**RE: LOT 2 DP1149138 – EASTERN CREEK
DEVELOPMENT APPLICATION (MP10_0082) FOR THE K-MART PROJECT**

ANNEXURE A – RESPONSE TO SUBMISSIONS

2. Response to a submission by Blacktown City Council , letter dated 23/8/10

Figure 8: Year 2016 Proposed Access Treatments

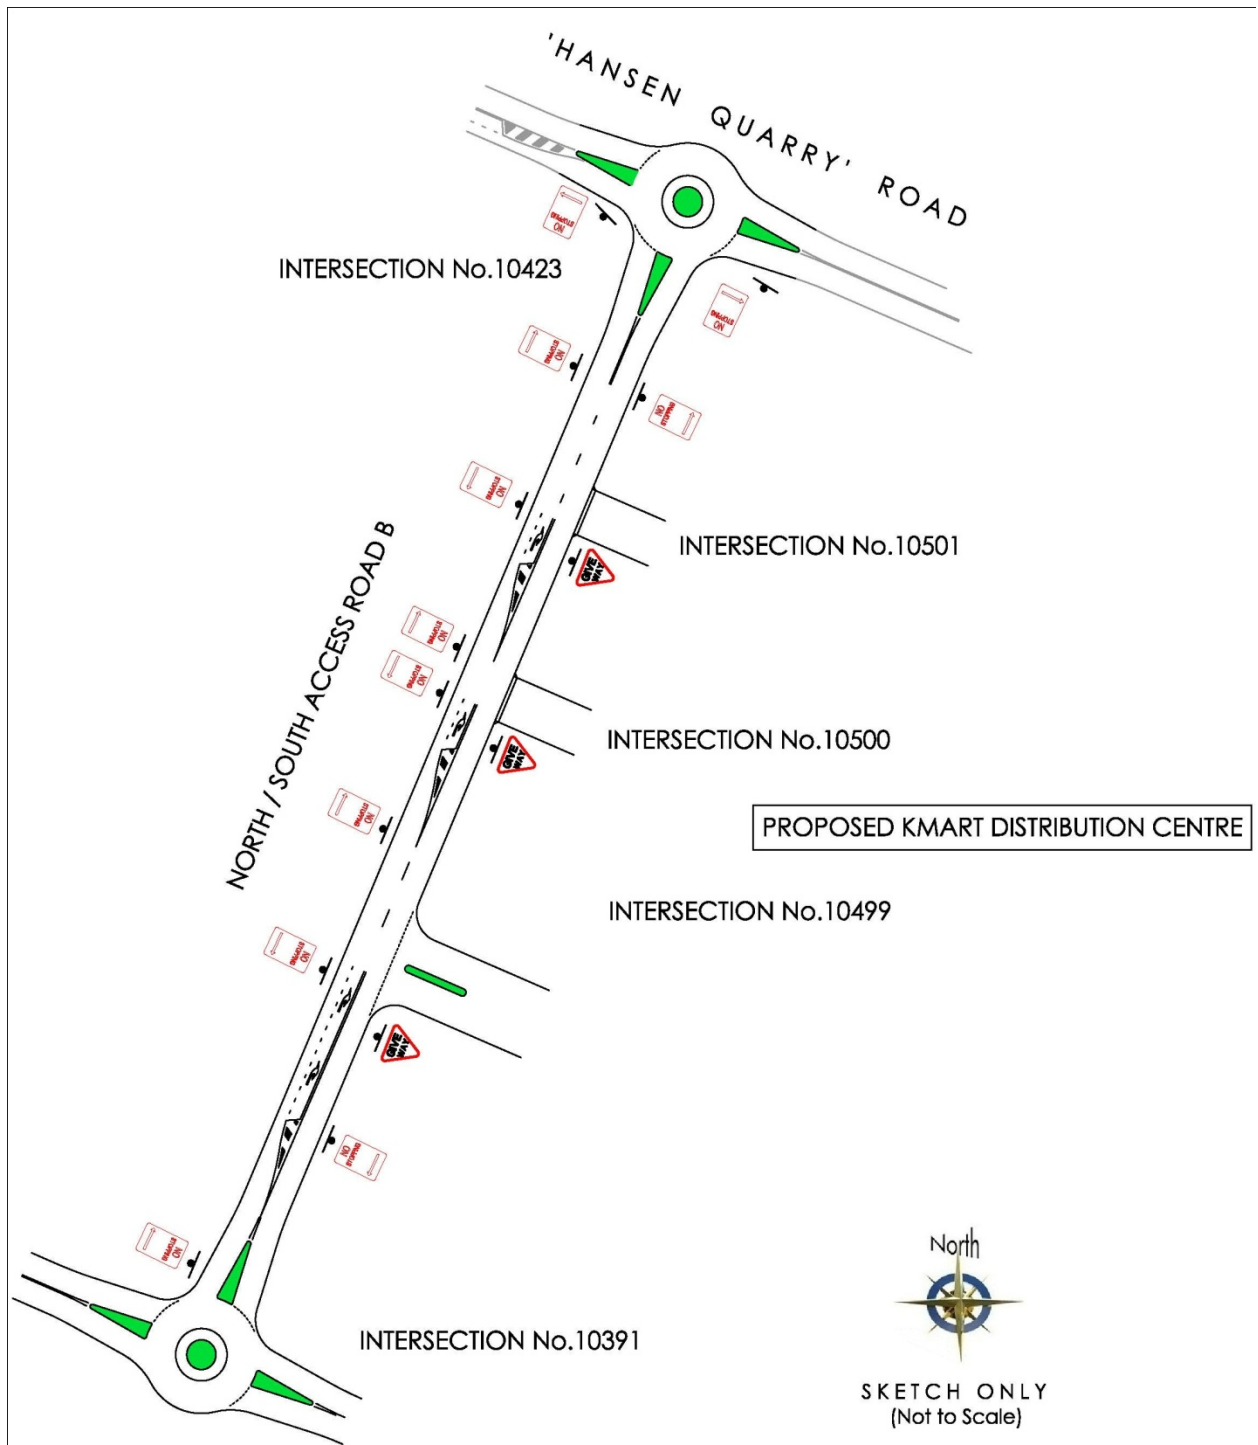
As per Figure 8 Council does not support designated right turning bays for various entry/exit points and associated "No Stopping" restrictions. Industrial roads are generally wide enough to allow a vehicle waiting to turn and other vehicles to pass the stationary vehicle.	<p>We have no objection to the proposal by Council. Our application is for the building. The comment on Road 4 (as shown in Fig 8) is subject to a separate application for Road 4 and has been conditioned by Council as the Consent Authority for this application.</p> <p>No further action is necessary.</p>
The location of the pedestrian crossing between the car park and the proposed office is very close to the bend, therefore it is considered unsafe as a turning driver may not be able to see a pedestrian.	<p>Disagree, there is adequate sight distance for entering trucks to see pedestrians on the crossing, with no visual barriers proposed on the application drawing that would obscure vision.</p> <p>No further action is necessary.</p>
